**July 16, 2014
DRB Comments**

PROJECT # 1009506

APPLICATION # 14-70238

RE: Montecito West, Unit 1

**Plat for  
 Montecito West, Unit 1  
 Being Comprised of  
 Lots 15-21, Volcano Cliffs Subdivision Unit 6  
 Together with a Portion of Vacated Retablo Road NW  
 and Albericoque Place NW Rights-of-Way  
 City of Albuquerque  
 Bernalillo County, New Mexico  
 July 2014**

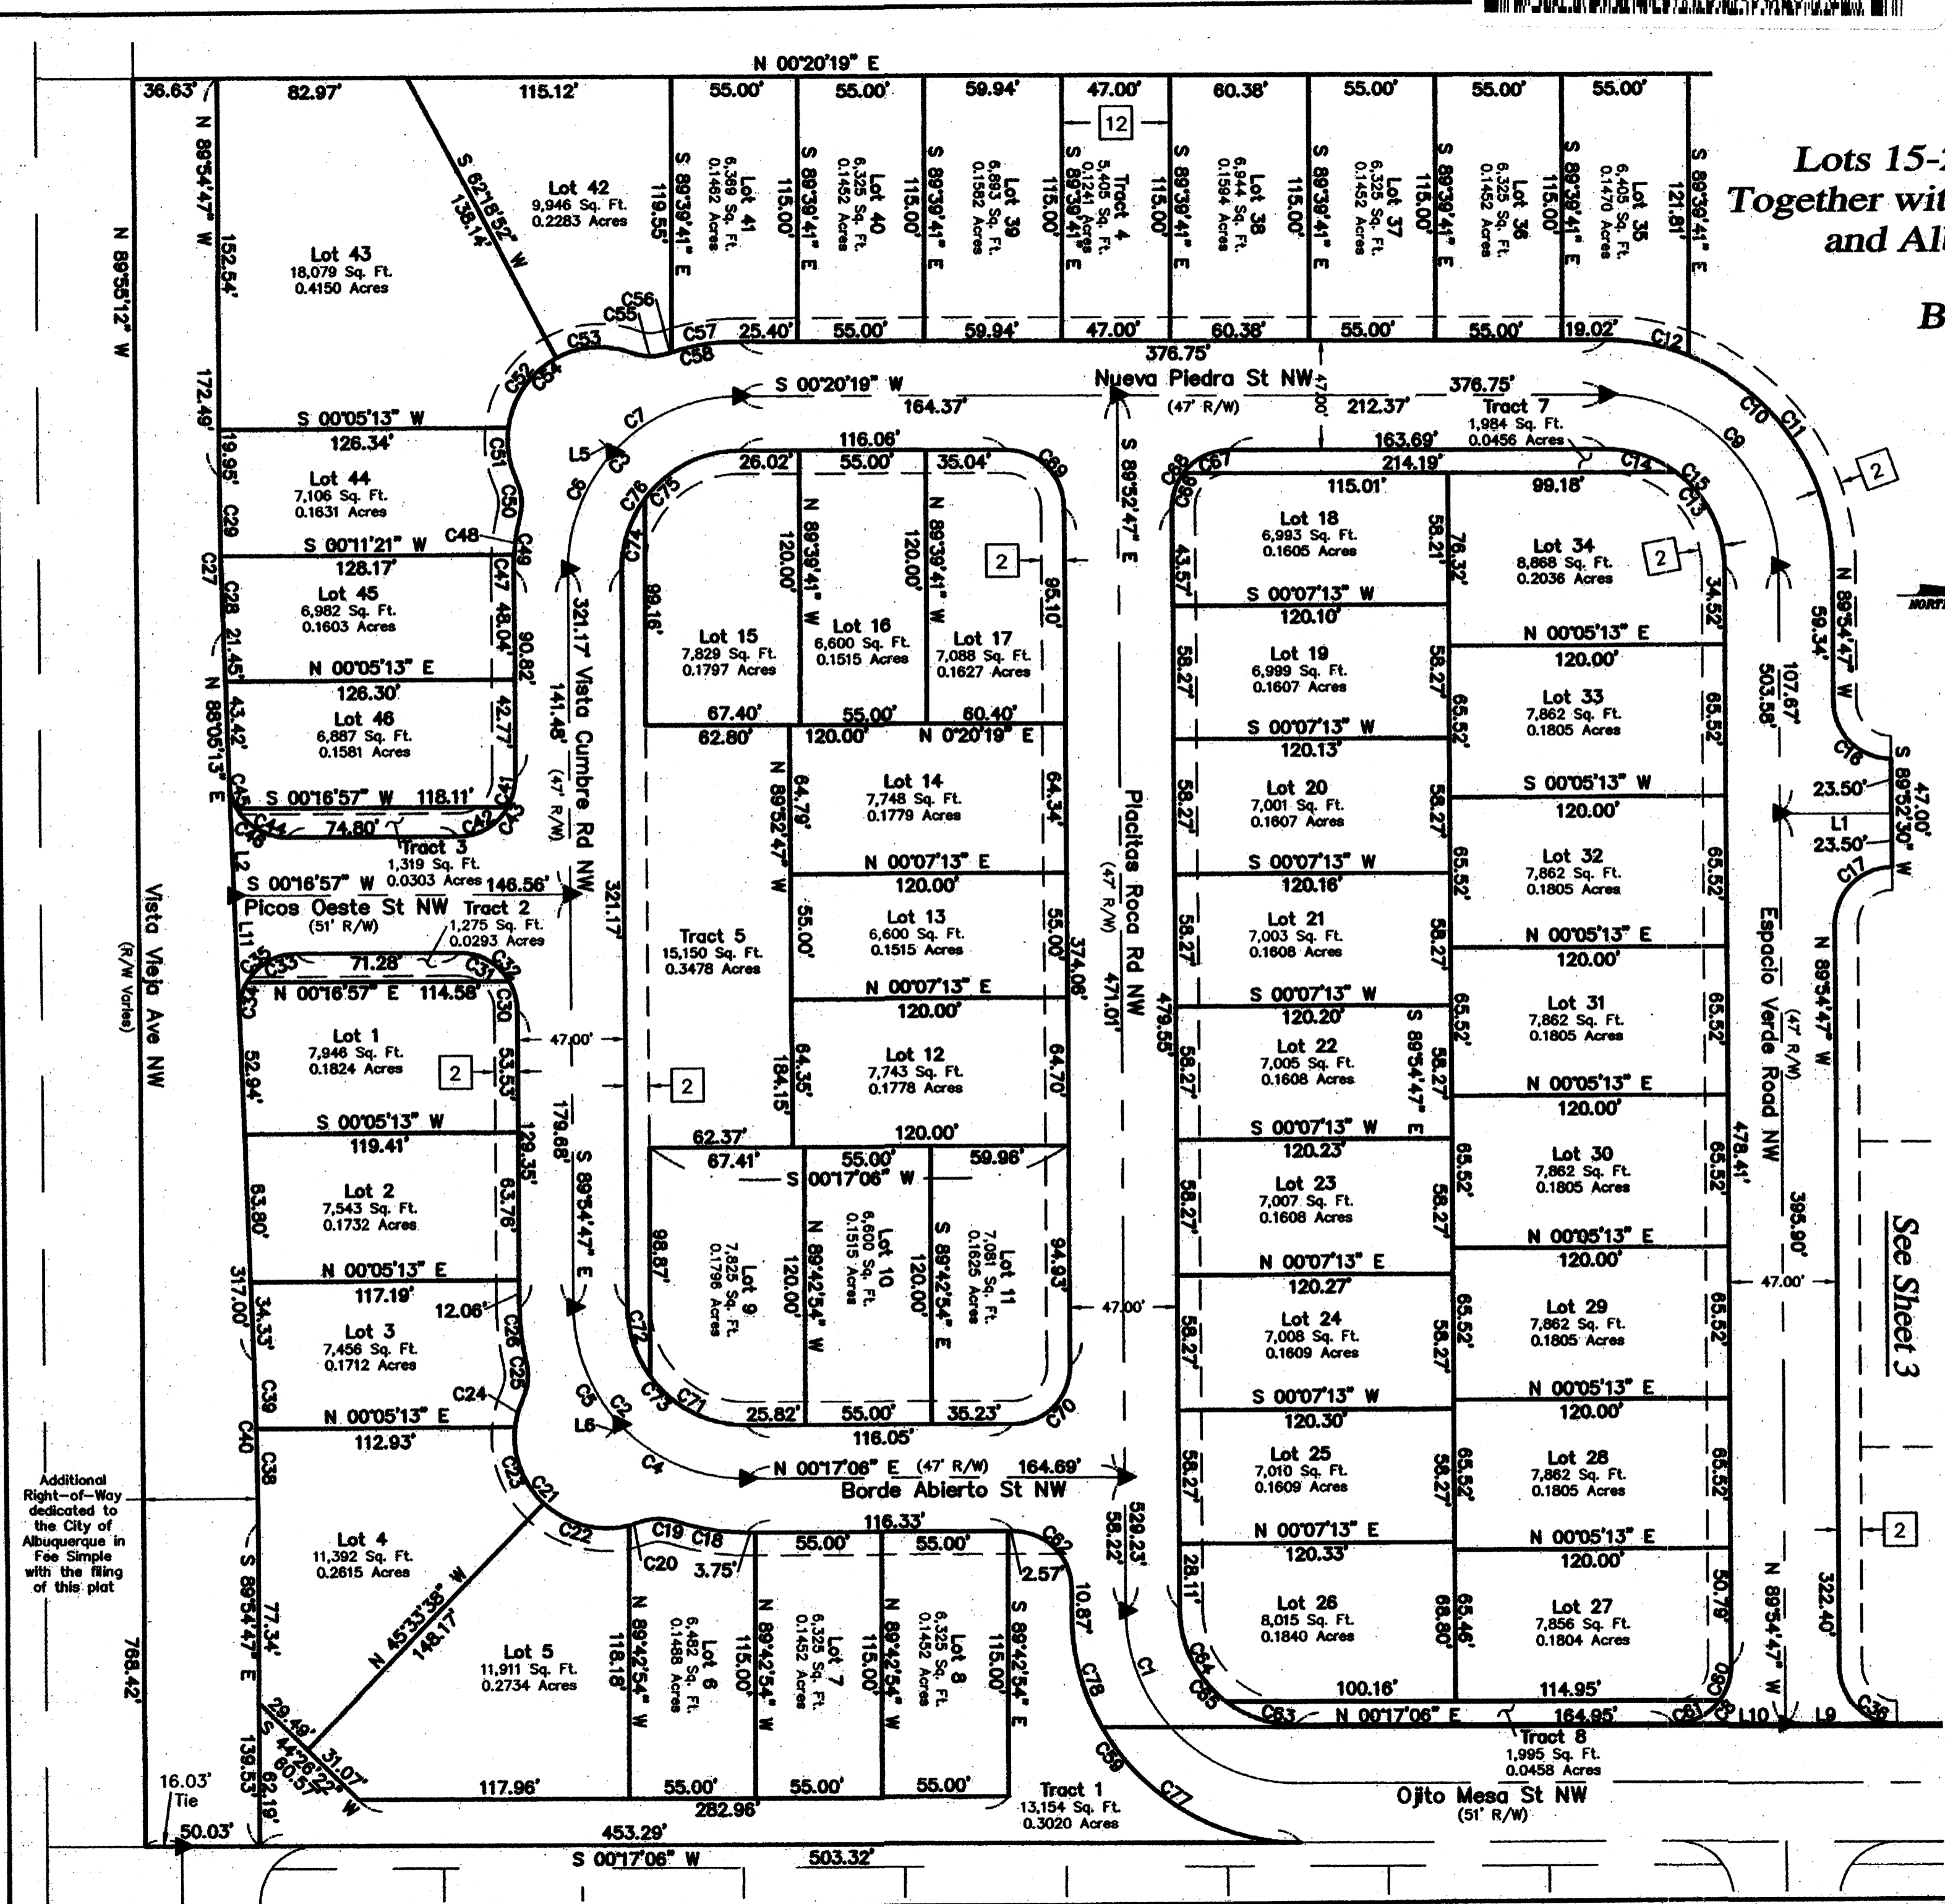
Tracts need to be identified on the plat (use, maintenance, etc.). Tract 6 was to be dedicated as City Open Space, so Open Space should be a signatory to the plat. Real Property needs to sign the plat to verify acquisition of vacated right of way.
